KIRKLEES METROPOLITAN COUNCIL INVESTMENT & REGENERATION SERVICE

DELEGATED DECISION TO DETERMINE PLANNING APPLICATIONS

Reference No:	2026/62/91118/E
Site Address:	Upper Soothill Community Centre, 1039, Leeds Road, Woodkirk, Dewsbury, WF12 7HY
Description:	Erection of two storey front and side extensions with perimeter fencing, access gates and associated alterations (part retrospective)
Recommending Officer:	Elenya Jackson

Officer Report.

1039 Leeds Road Dewsbury WF12 7HY		
TITLE	Retorspective application for perimeter security fencing and automatic sliding gate For Planning Purposes Only	
JOB No.	DRAWING No. 001	REVISION
CLIENT	Upper Soothil Masjid	
SCALE	As shown @A1 print actual size not scale to fit	
DATE	09/02/2026

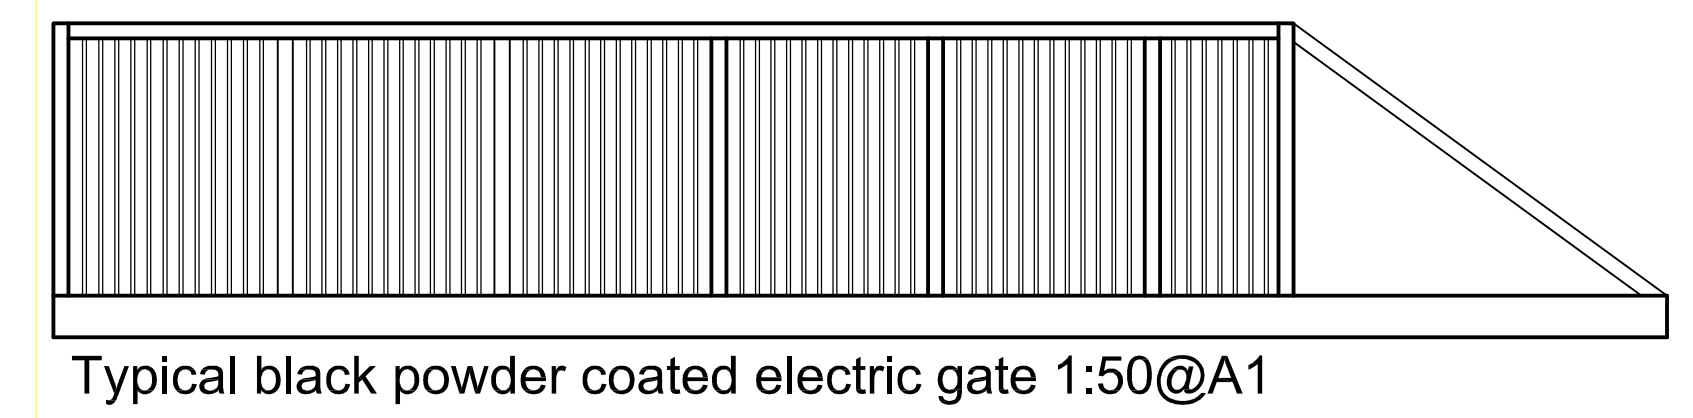
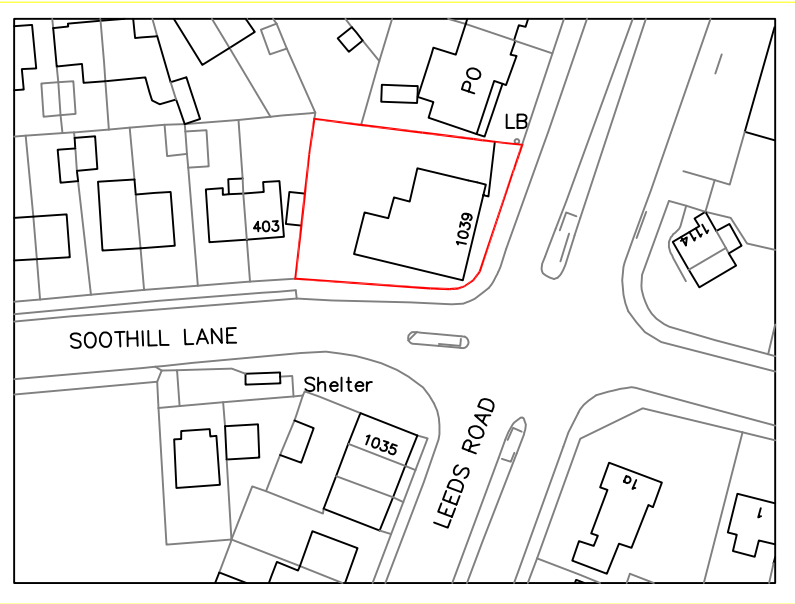
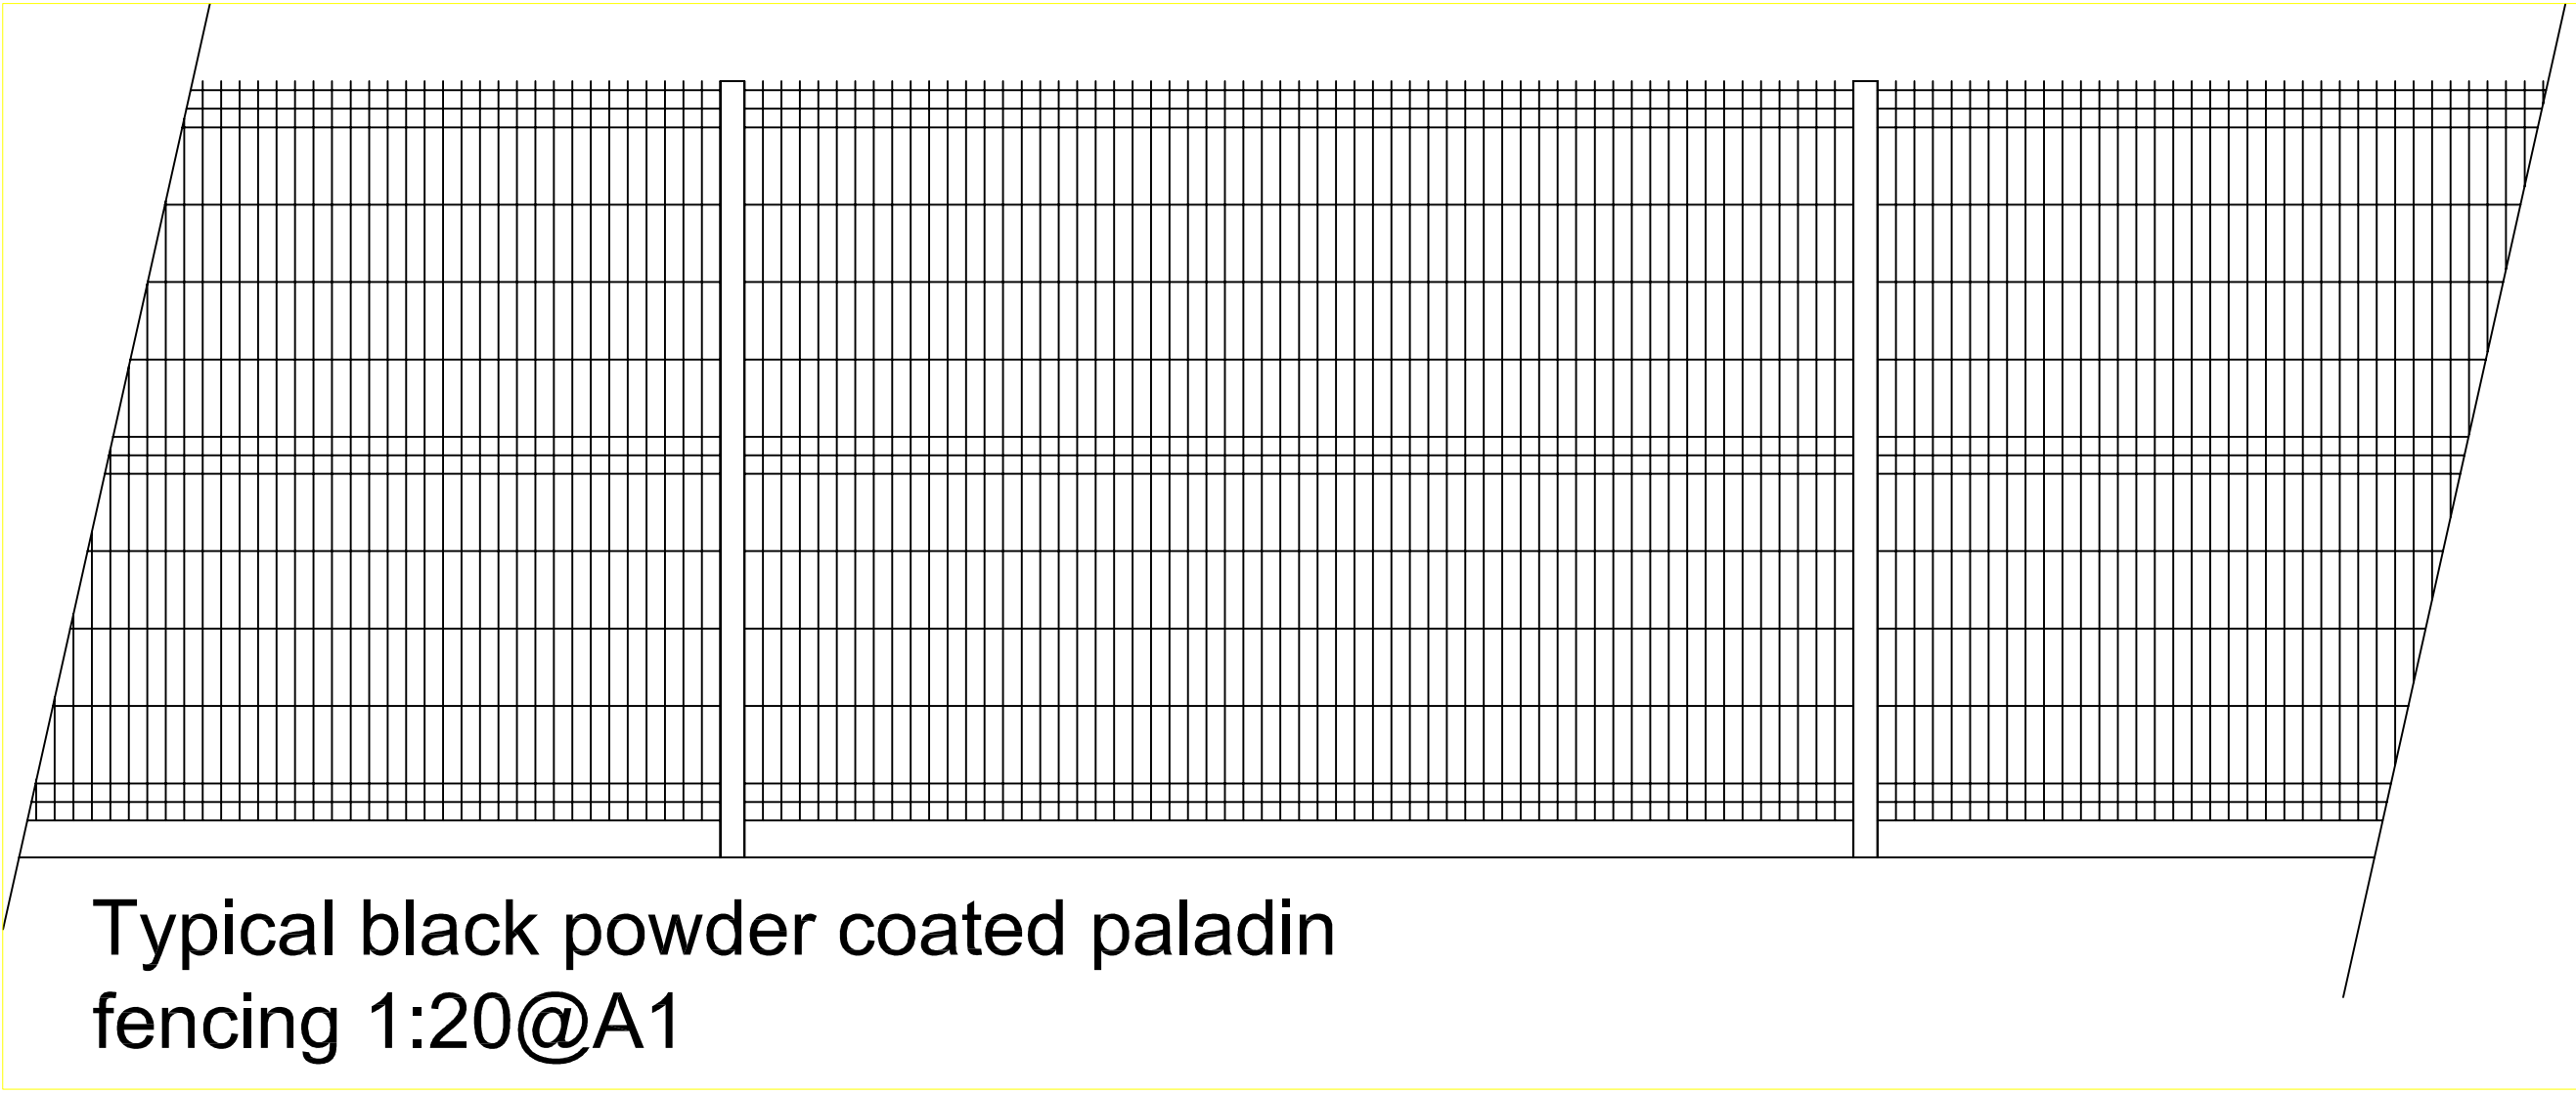
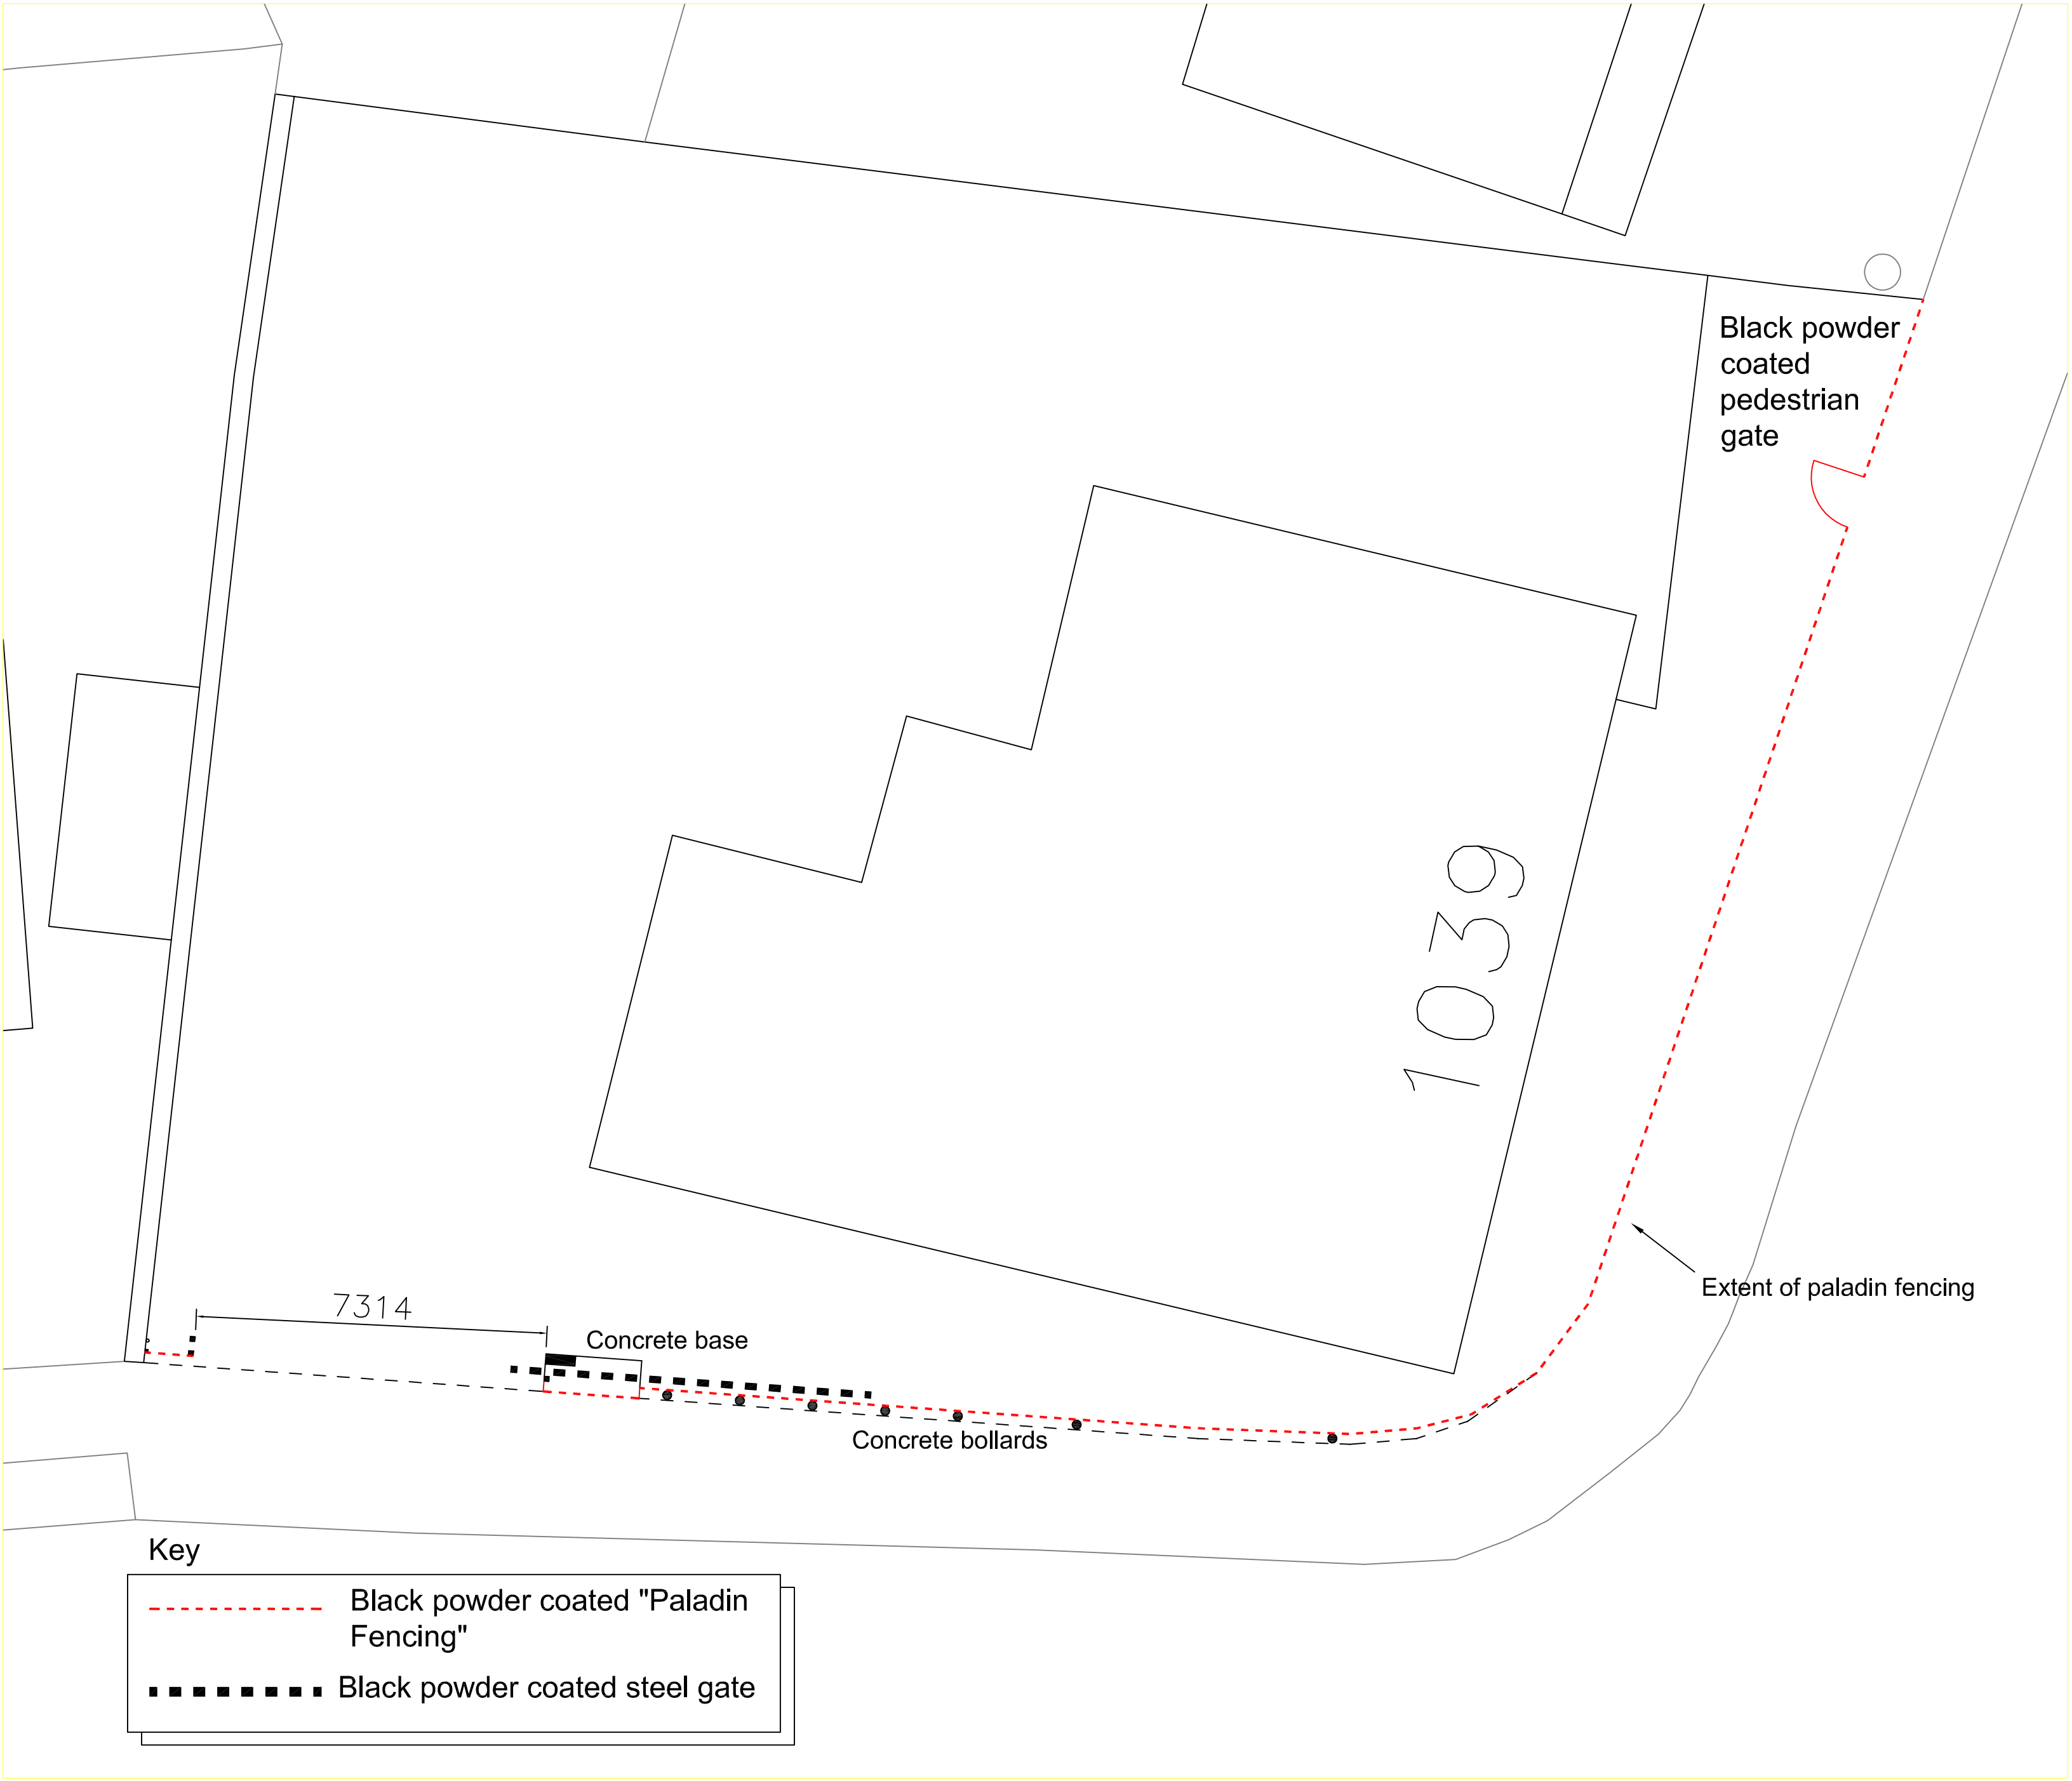
Finally, the proposal would include the enclosure of the site via the erection of paladin fencing.

The proposal also includes the erection of paladin fencing, which it is considered is appropriate given the use of the site and necessary to secure the security of the building and its users. Officers propose a condition that should the use of the building cease, the fencing is to be removed, in the interests of visual amenity.

2. The fencing hereby approved and associated works shall be removed in its entirety prior to the expiration of 3 months from the date that the building ceases to be in use as a community facility.
